Our ref: RA/2023/145899/09-L01
Your ref: 2023/91441
Date: 19 February 2026

**CHANGE OF USE AND ALTERATIONS TO FORMER CHURCH (B8-STORAGE)
TO 9 RESIDENTIAL UNITS (C3) AND FORMATION OF CAR PARK (LISTED
BUILDING WITHIN A CONSERVATION AREA)**

AT 31 CHAPEL HILL, LINTHWAITE, HUDDERSFIELD, HD7 5NJ

- Flood risk technical note - titled RE: Chapel Hill, Linthwaite Proposed Car Parking Deck Structural Intent Summary, reference 23345, dated 24/11/2025, prepared by Dudleys Consulting Engineers
- Drawing number 23345-XX-XX-XX-DR-101, revision C01, dated 18/11/2025
- Drawing number 23345-XX-XX-XX-DR-103, revision C01, dated 18/11/2025

| 23345-XX-XX-XX-DR-101 | P03  |

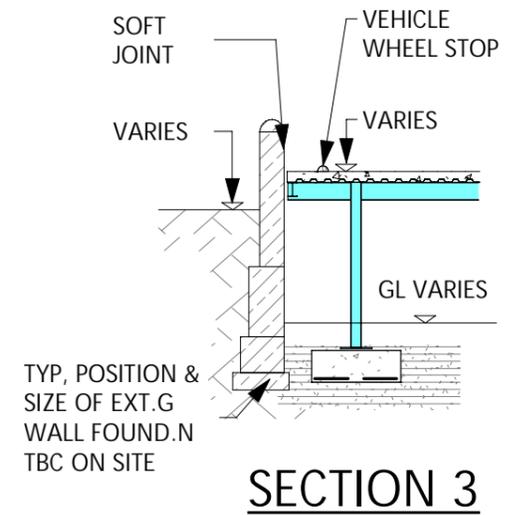
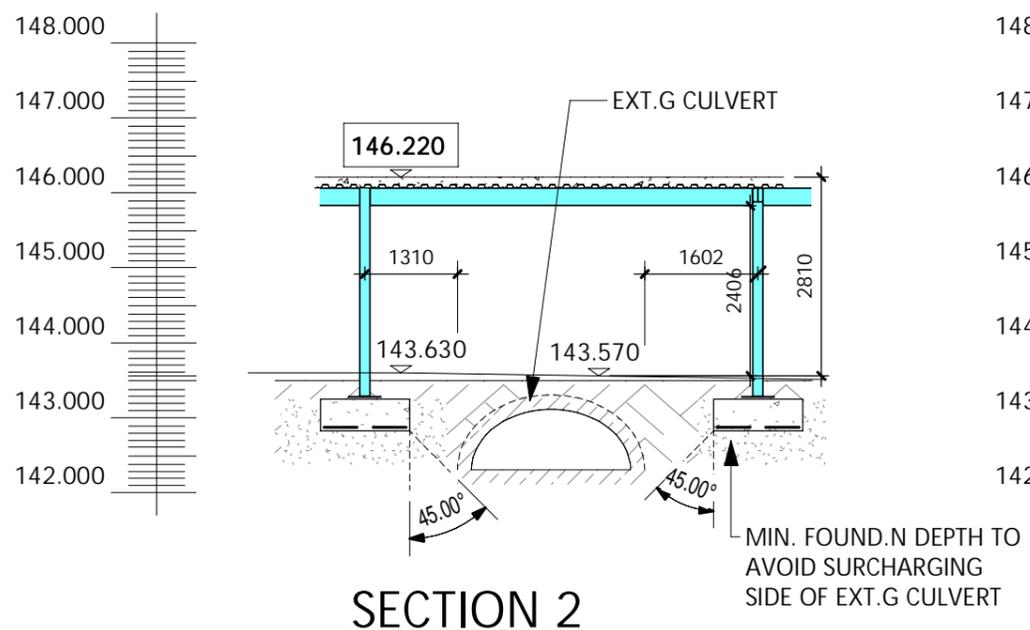
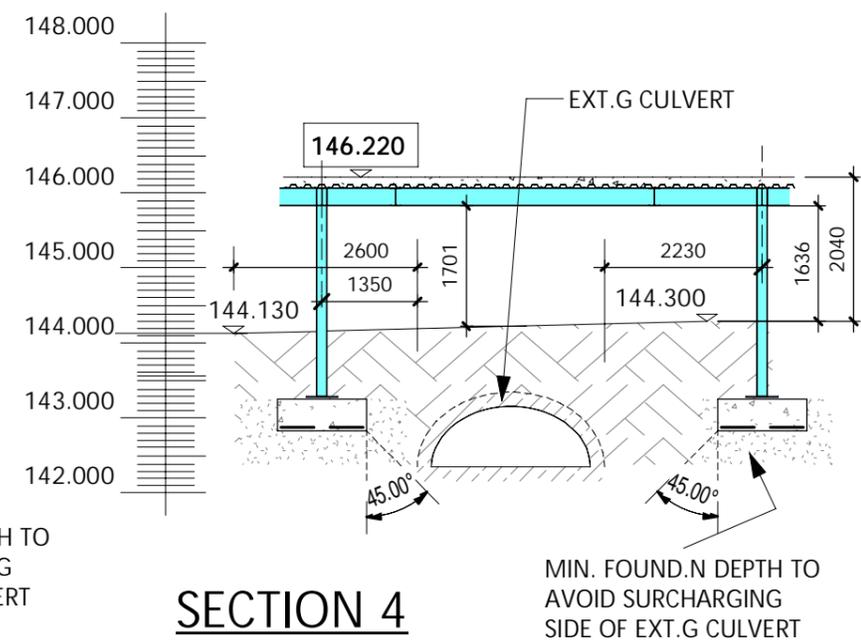
- The car park deck shall be raised to allow access to the culvert, as shown in drawing number “23345-XX-XX-XX-DR-101”, revision C01, dated 18/11/2025
- The foundations shall be constructed outside of the 45-degree easement as measured from the outer edge of the base of the culvert, as shown in drawing number “23345-XX-XX-XX-DR-101”, revision C01, dated 18/11/2025 and “23345-XX-XX-XX-DR-103”, revision C01, dated 18/11/2025
